Subject: Executors of N Alington – Little Barford Estate – A428
From: Bidwells
Date: 17/02/2022

SUMMARY OF COMMENTARY AND REPRESENTATIONS AND CONCLUSION OF POSITION STATEMENT ON BEHALF OF THE LANDOWNER

APPENDIX 6 EXECUTOR'S PROPOSAL

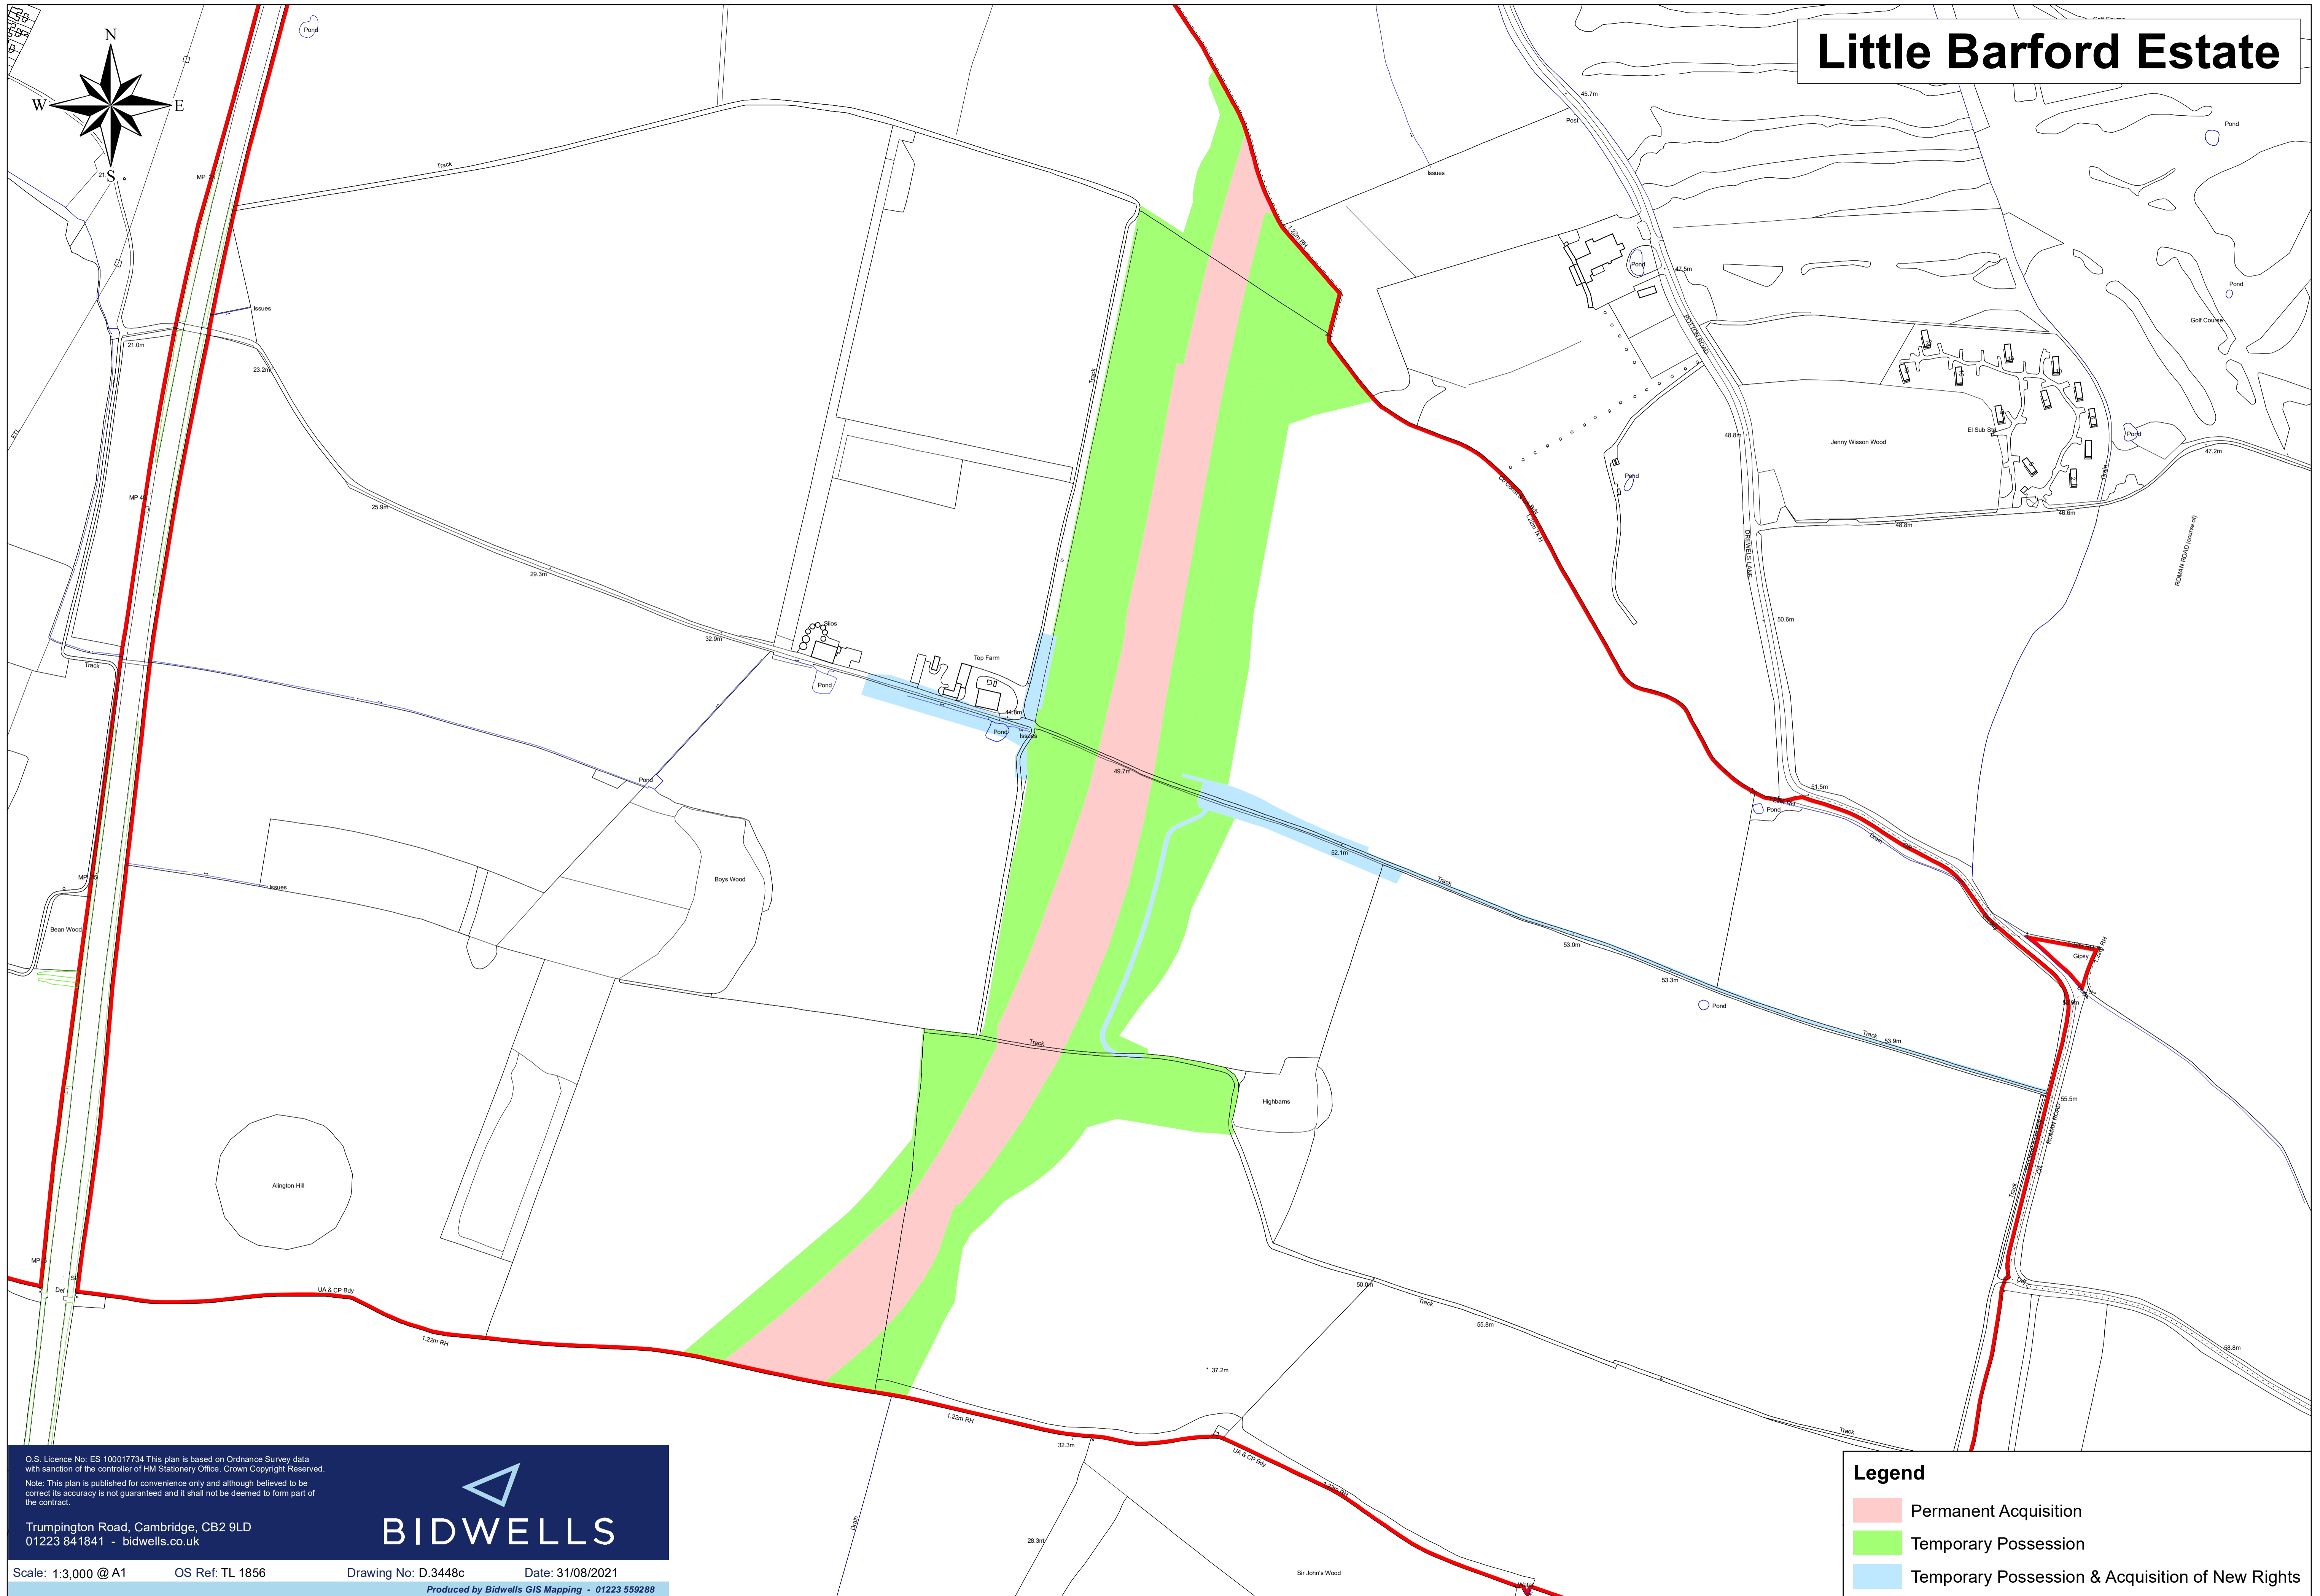
The Executors object to the extent of woodland planting and the extent of land being permanently acquired for this purpose. In particular, an area of land located to the west of the A428 takes out a block of arable land and disrupts connection between two fields.

The Executors offered an alternative location immediately adjacent to existing woods, which would appear to have achieved the same effect. However, National Highways has not been able to agree this. This is apparently because this wood has been labelled as essential mitigation and, therefore, it has a legal obligation to provide this woodland and to maintain sufficient control to ensure delivery.

It has provided no ecological reason why this woodland should be located where proposed, nor an ecological reason for the other locations being inappropriate.

3. The overbridge matter has been agreed in principle, with a bridge of sufficient width to enable safe clearance for 6m wide machinery.
4. The Executors maintain the objection to the location of a block of woodland to the west of the A428 on the grounds that a similar, if not better, ecological result could meet the mitigation objectives, which could be achieved by locating this woodland adjacent to existing wood. The Executors would be willing to grant to rights to do this.
